**KIRKLEES COUNCIL
TOWN AND COUNTRY PLANNING ACT 1990
HIGHWAYS DEVELOPMENT MANAGEMENT**

PLANNING REF 2018/62/91661/E0/GW
CATEGORY Small Major

PROPOSAL OUTLINE PERMISSION FOR RESIDENTIAL DEVELOPMENT AND FACILITATING ENGINEERING OPERATIONS AND FULL PLANNING PERMISSION FOR ACCESS AND SPINE ROAD

LOCATION LAND AT WALKLEY TERRACE AND BRUNSWICK STREET, HECKMONDWIKE

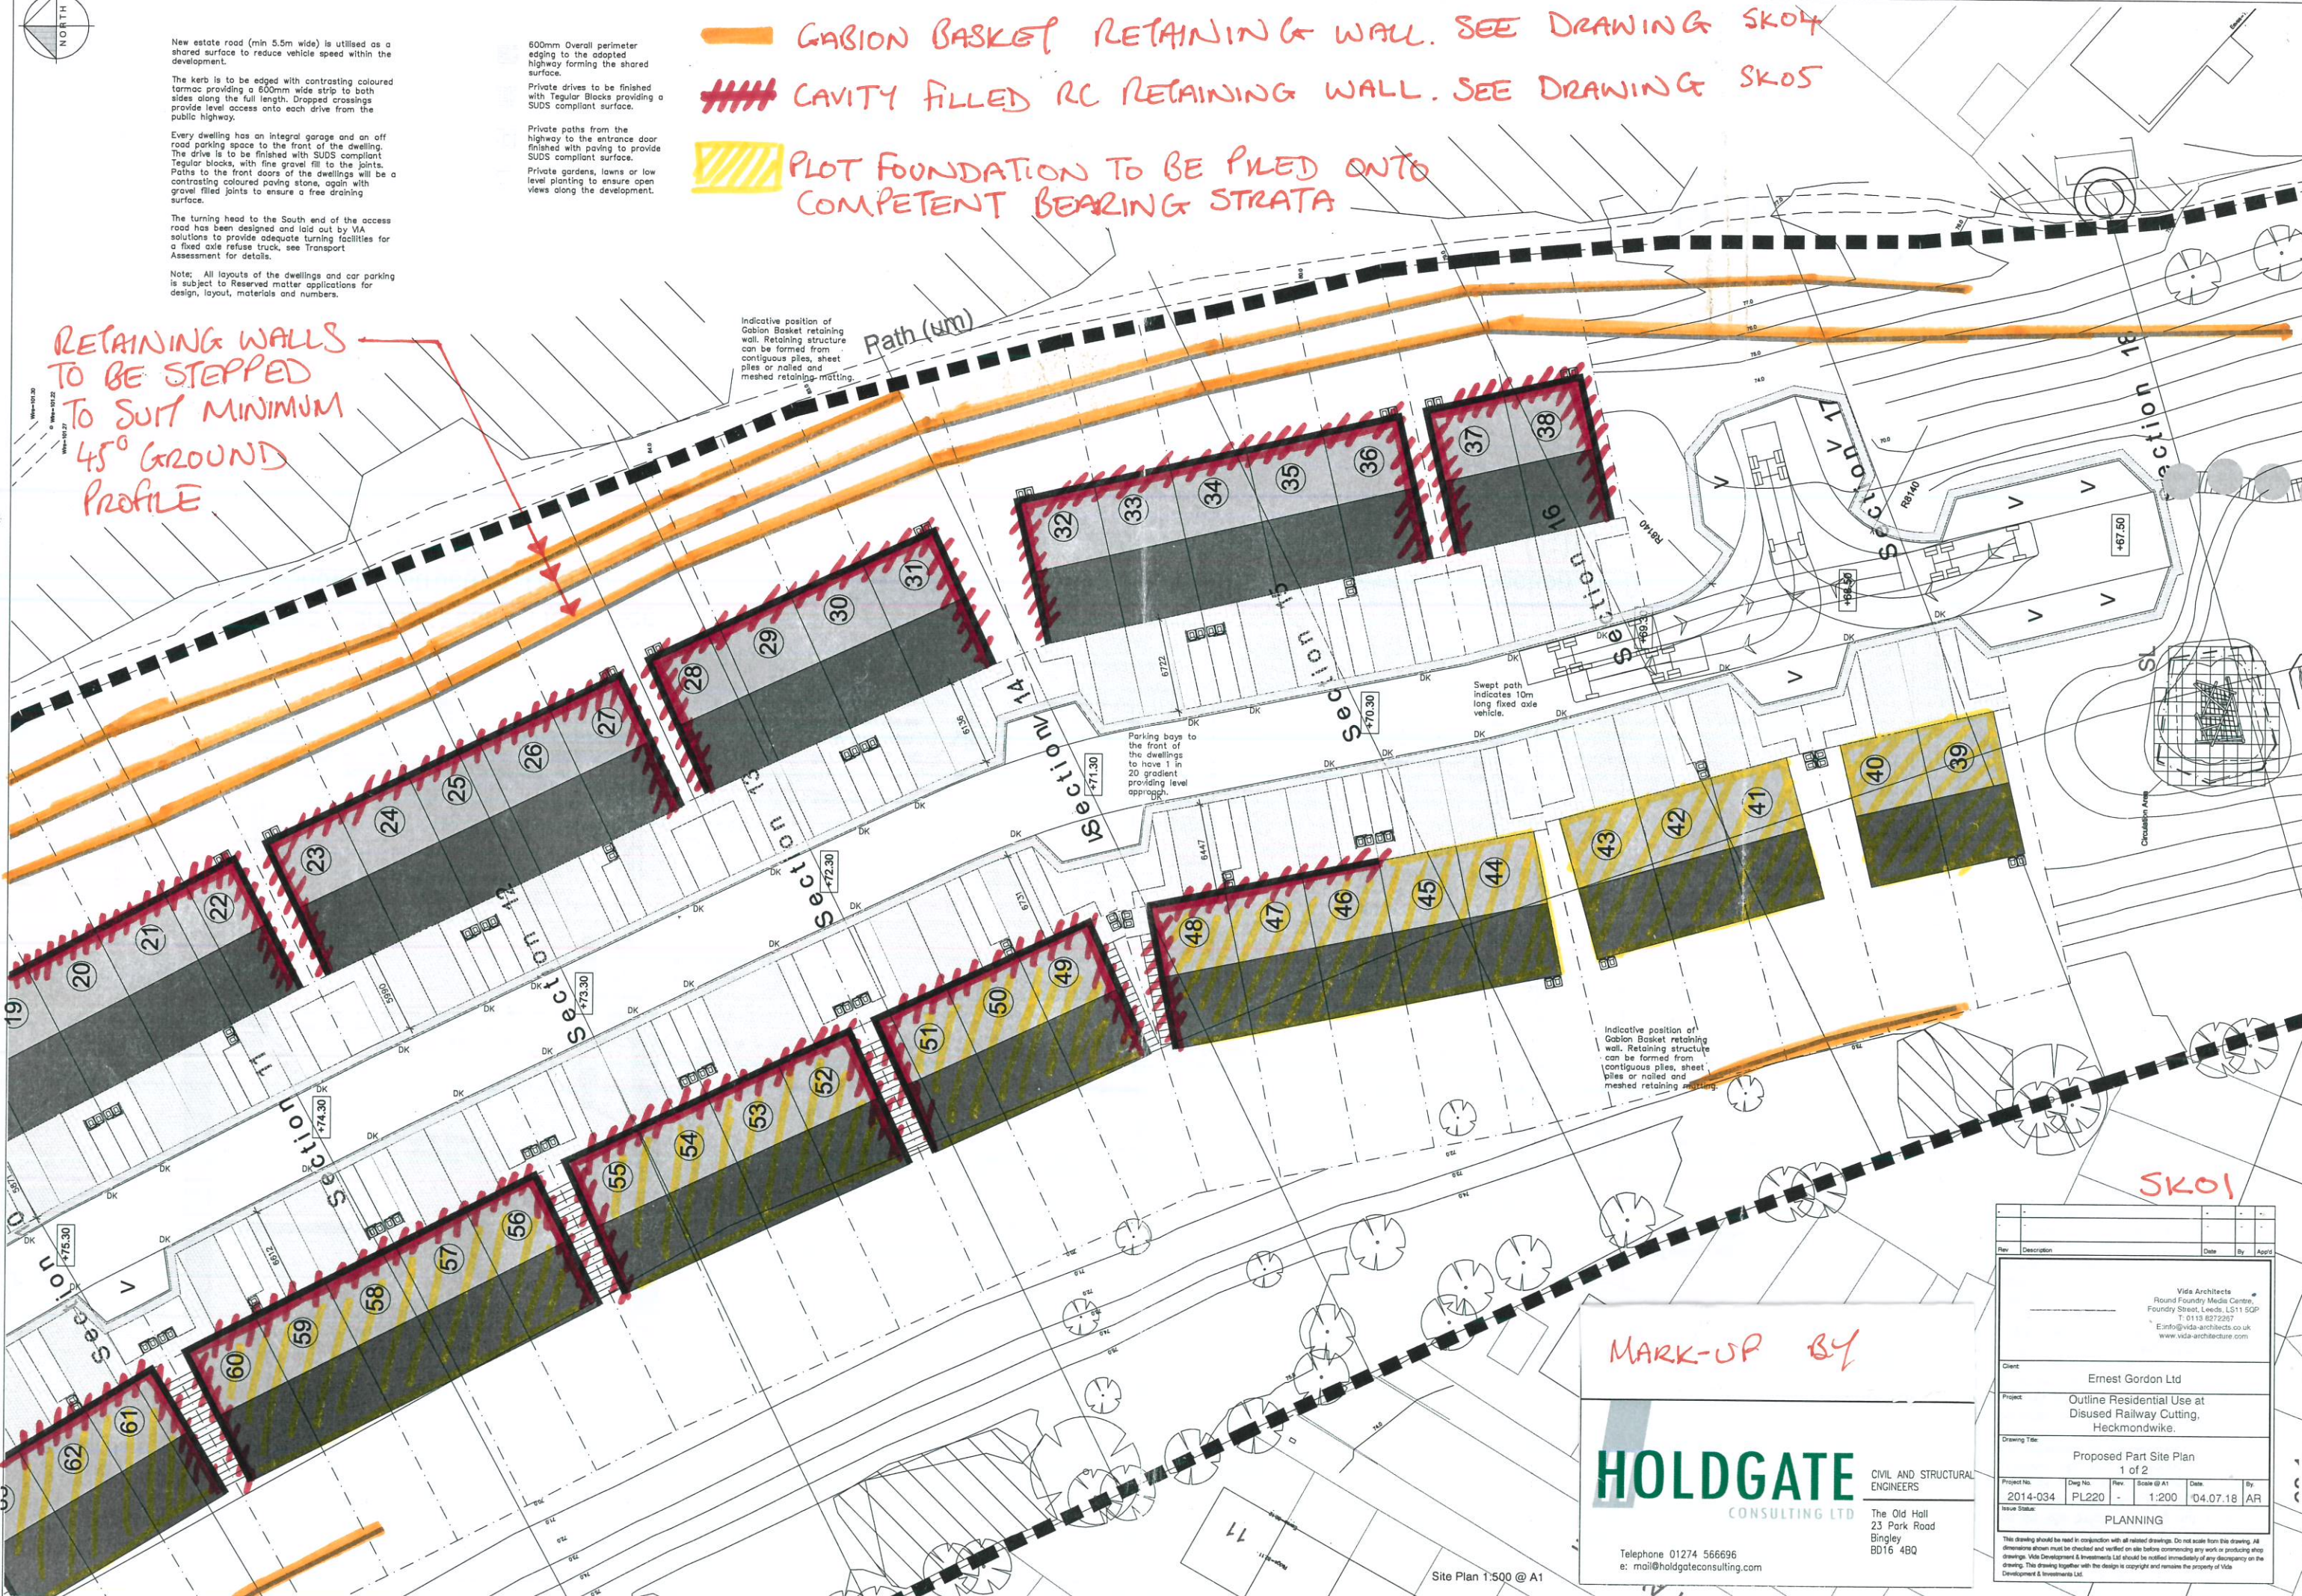
The proposed shared surface carriageway serving the proposed housing is relatively long and straight for a road of this type and with a carriageway width of 5.5m this road layout is unlikely to result in a design speed of 15mph. This type of road layout should be angular with alignment shifts. Consideration should be given to the provision of a footway to one side and redesign to include a restriction points. Footways should be 2.0m in width.

The proposed visitor parking spaces are not well spaced along the length of the proposed road. They are also insufficient in size and the splays are insufficient. Visitor parking bays should be 6.0m at the rear with 30 degree splays.

The steep slope immediately adjacent to the visitor parking is unacceptable.

Similarly the retaining wall proposal is unacceptable.

There are no pedestrian crossing facilities shown on the site plan drawing. There should be a pedestrian transition facility shown between traditional estate road and the shared surface areas. Where ramps are placed to demarcate different surfaces, the footways should continue beyond the ramp to provide for level pedestrian crossing of the carriageway. Where ramps or other traffic calming features are proposed, they should be positioned to avoid creating or exacerbating captive low points.

Section 8

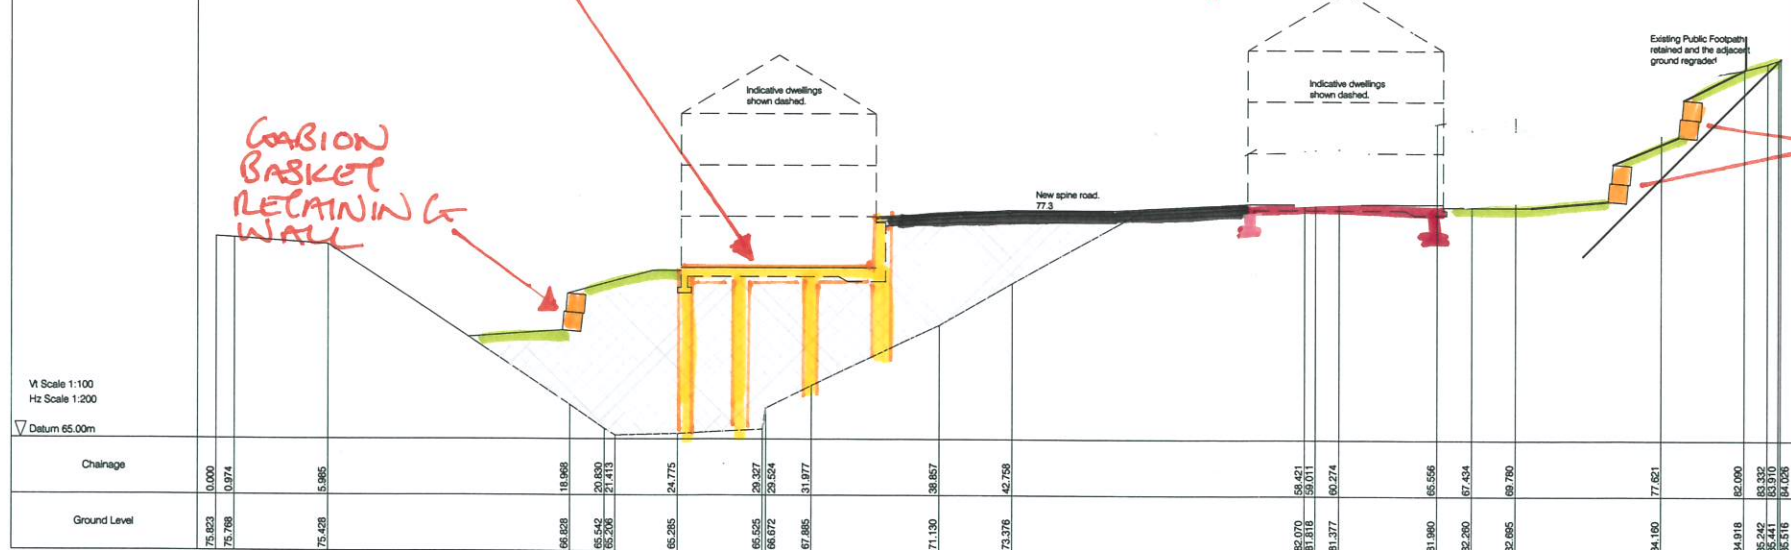
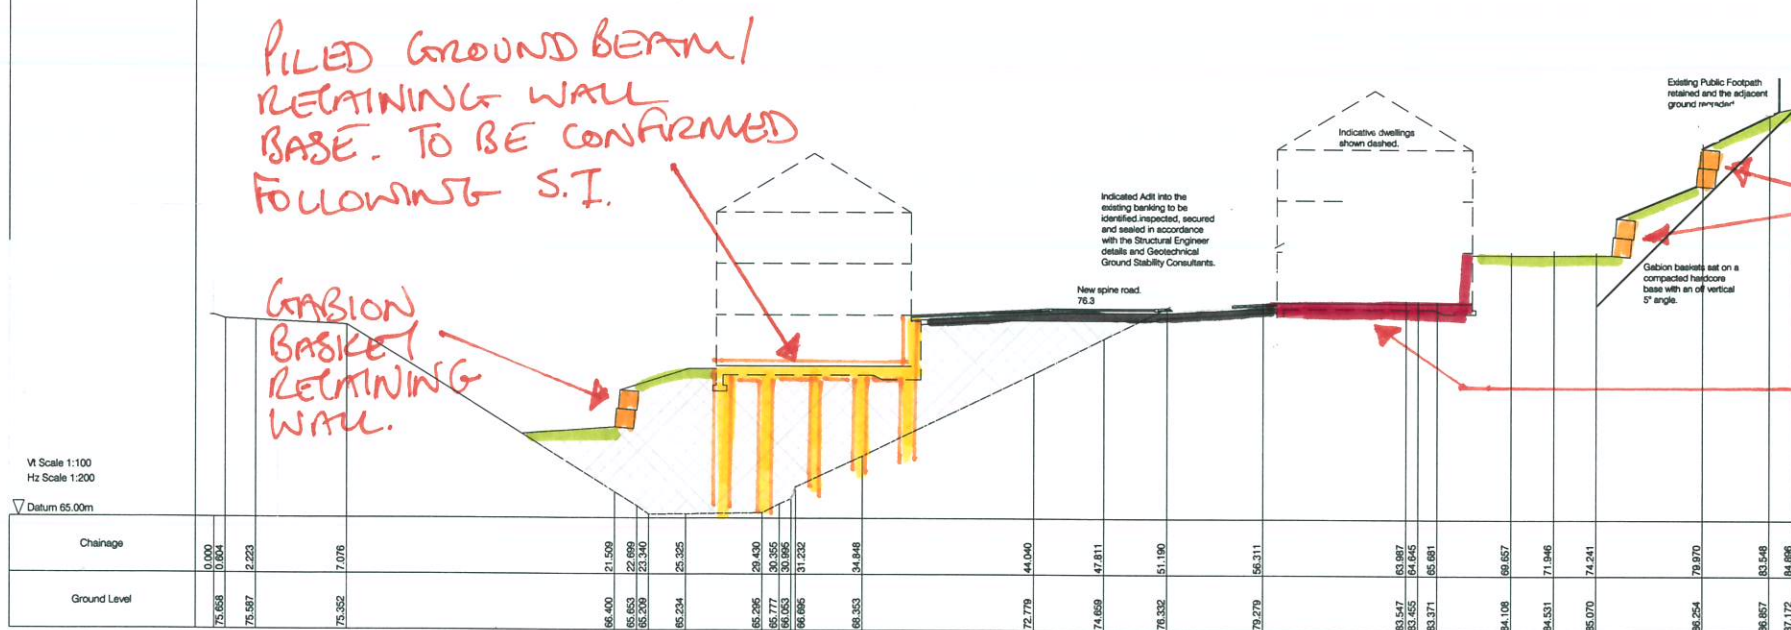
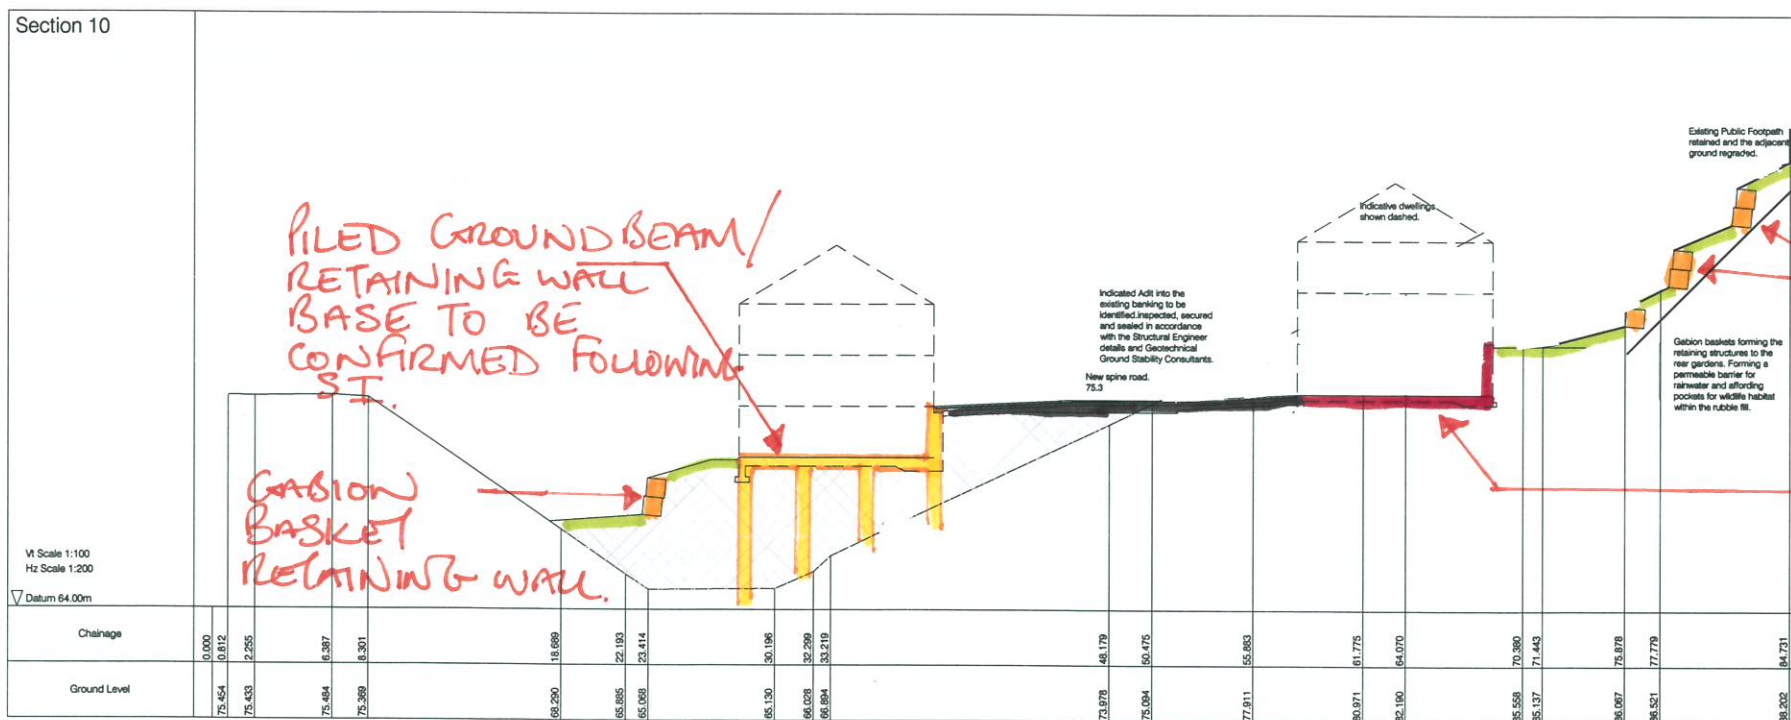
No chainages or gradients are shown on the longitudinal sections. The maximum acceptable gradient to a shared surface carriageway is 1 in 20. Scaling from the plans a 1 in 21 gradient is proposed. This should be confirmed and shown on the longitudinal sections.

Drawing No.
SK04

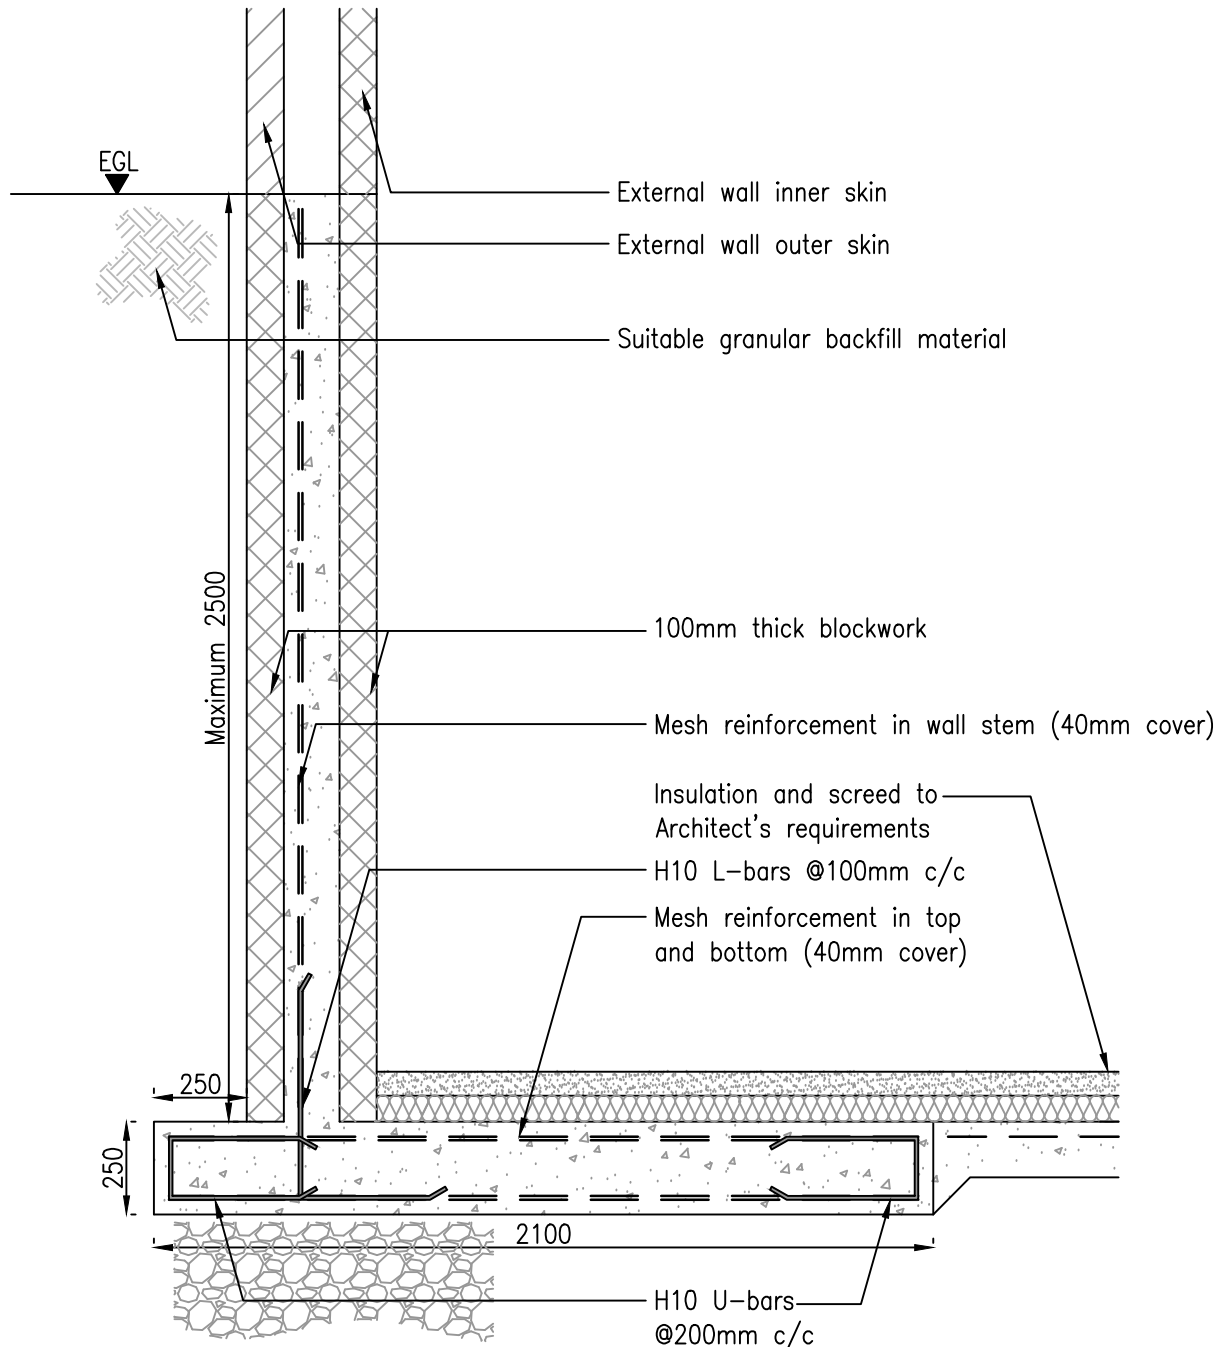
Any retaining features affecting the highway will require formal technical approval by the Council as

the Highway Authority. I would recommend providing details of all proposed retaining features and underground storage facilities (including pipes) to my colleague Farhad Khatibi (Team Leader) in the structures section at the earliest opportunity, who will be able to advise you of the necessary requirements in more detail.
